From: Sarah Burrow <Sarah.Burrow@arun.gov.uk>
Sent: 16 June 2021 16:39
To: Planning.Responses <Planning.Responses@arun.gov.uk>
Cc: Jasmine Kaur Singh <Jasmine.KaurSingh@arun.gov.uk>
Subject: RE: Planning Consultation on: AB/48/21/PL

Engineers Comments Regarding Surface Water Drainage

Site Address: Land adjacent to Woods Way House 3 Torton Hill Road Arundel BN18 9HF

Description of Works: Construction of 1 No. three bedroom dwelling & associated works. This site is in CIL Zone 2 & is CIL Liable as new dwelling.

Site/Block Plan

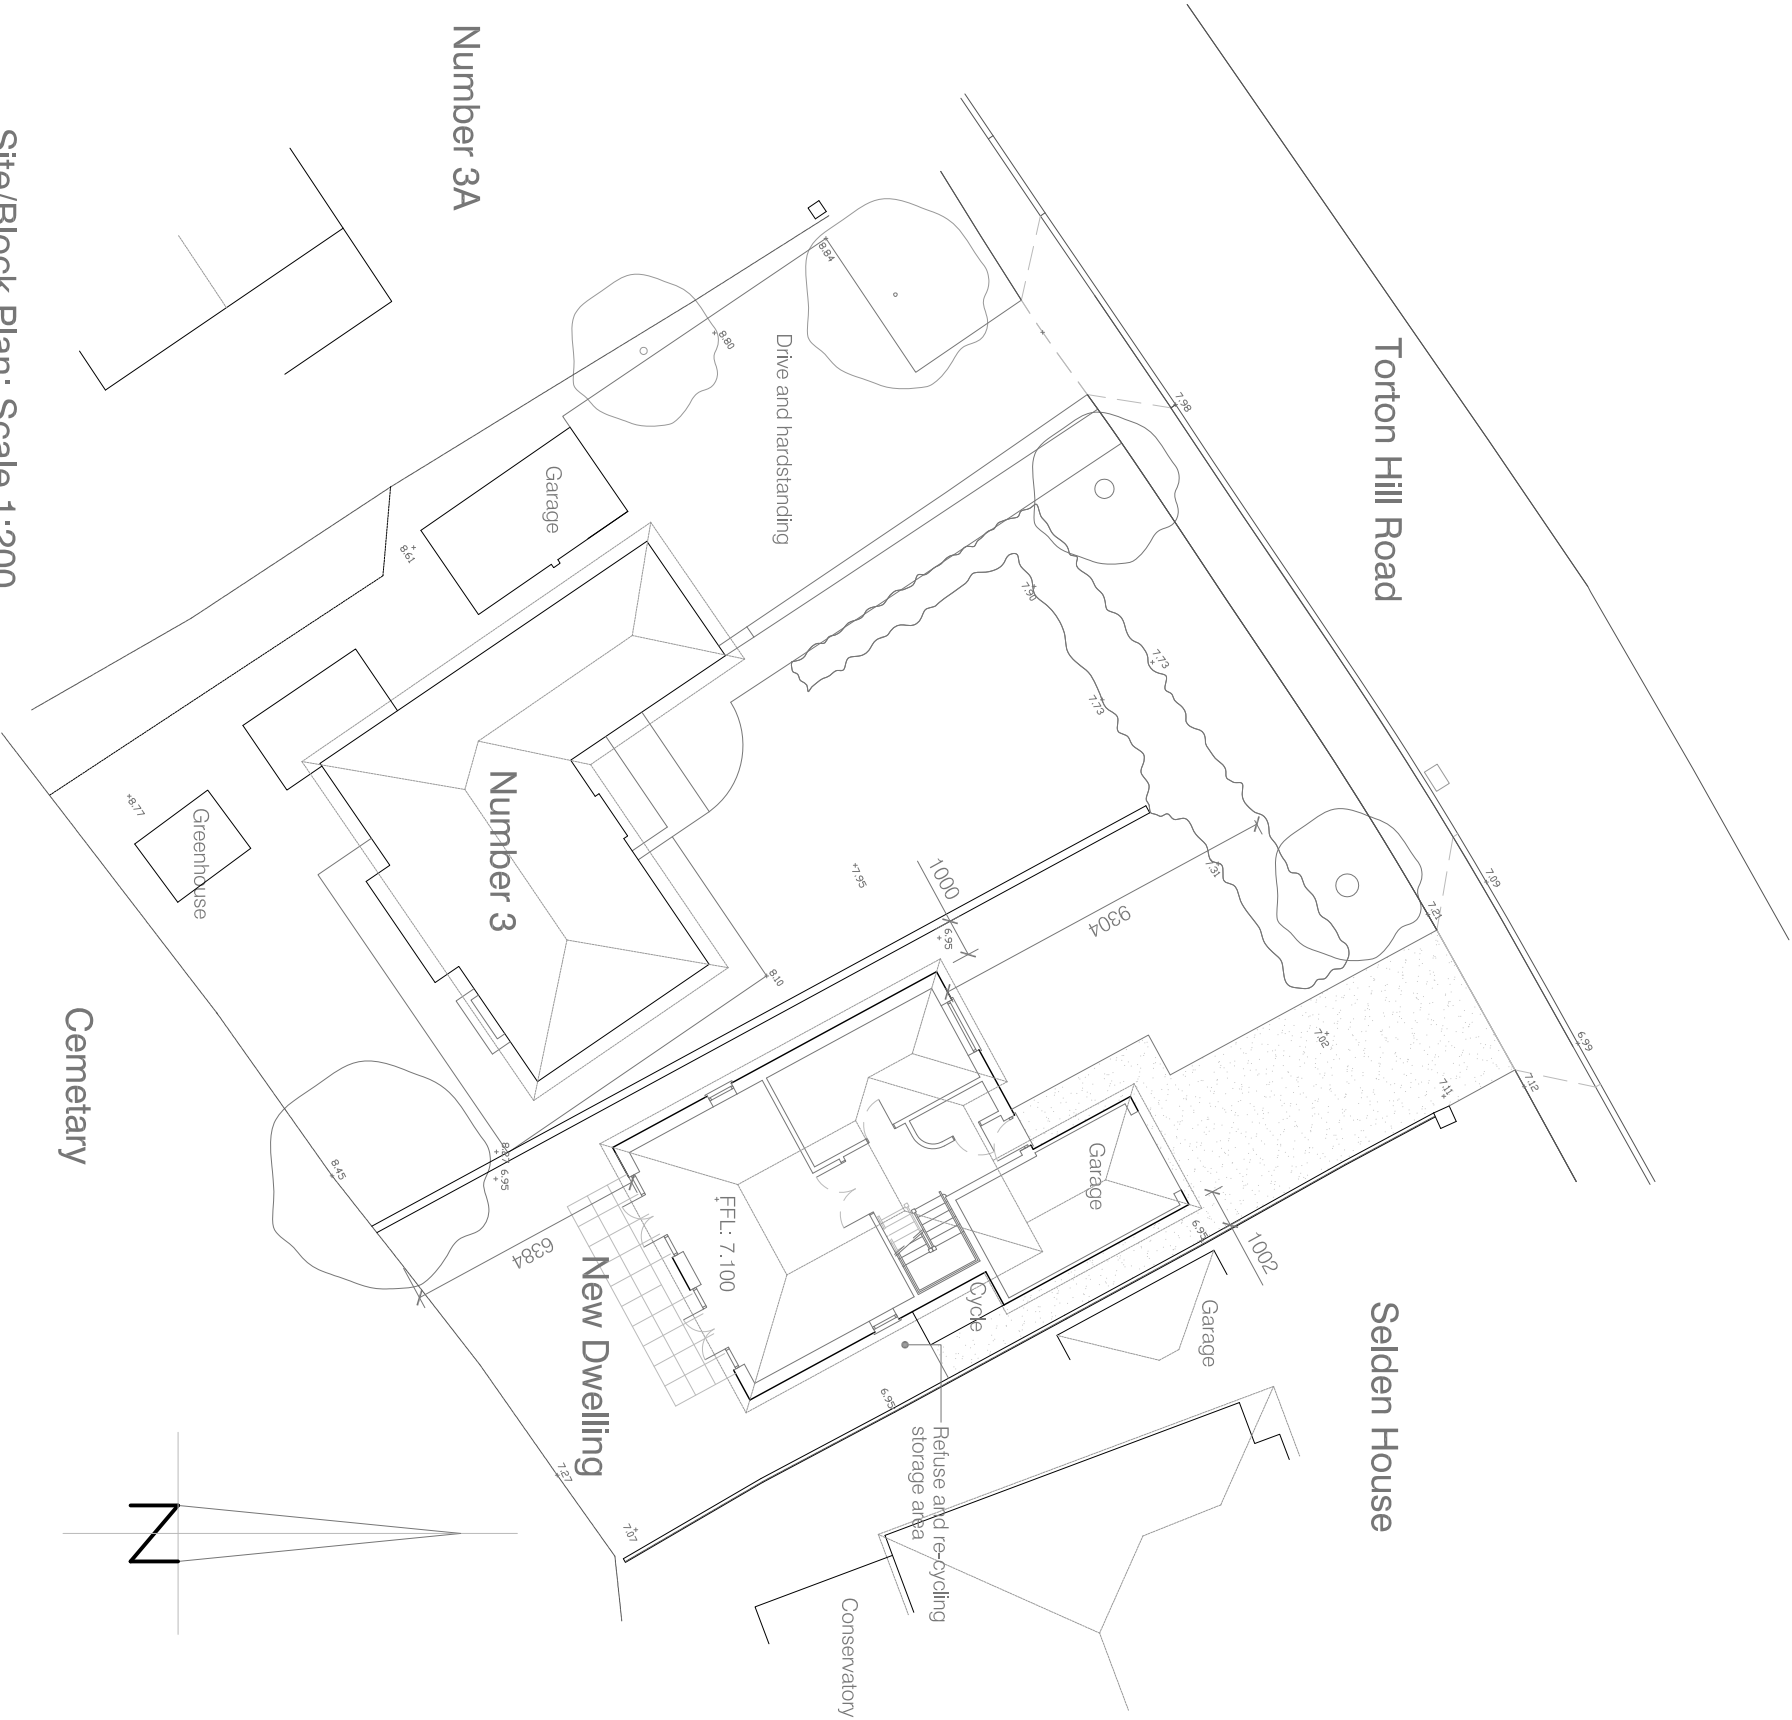
I wish to lodge a **holding objection** to this application. The hierarchy for sustainable drainage must be followed, therefore infiltration must be prioritised above discharging to a watercourse or a sewer. However, is it unclear if there is enough space on the site to support infiltration features (5m from buildings and highway, 2.5m from property boundaries). Having insufficient space is an unacceptable excuse for not following the hierarchy, particularly as there is no surface water sewer in the vicinity of the site and we oppose all connections of surface water to the foul sewer.

It is also noted that our mapping shows the foul sewer running adjacent to Woods Way House on the eastern side. **Please consult Southern Water** with regards to this proposal as they will require an easement to this sewer which may not be achievable with the proposed site layout.

To overcome my objection the applicant should complete winter groundwater monitoring and winter infiltration testing and complete calculations to assess the size of structures required. A rough plan should be formed showing where these structures can be provided within the proposed layout. If the applicant has evidence that infiltration will not be viable on the site this should be supplied and a basic attenuation design with an appropriate outfall location should be supplied.
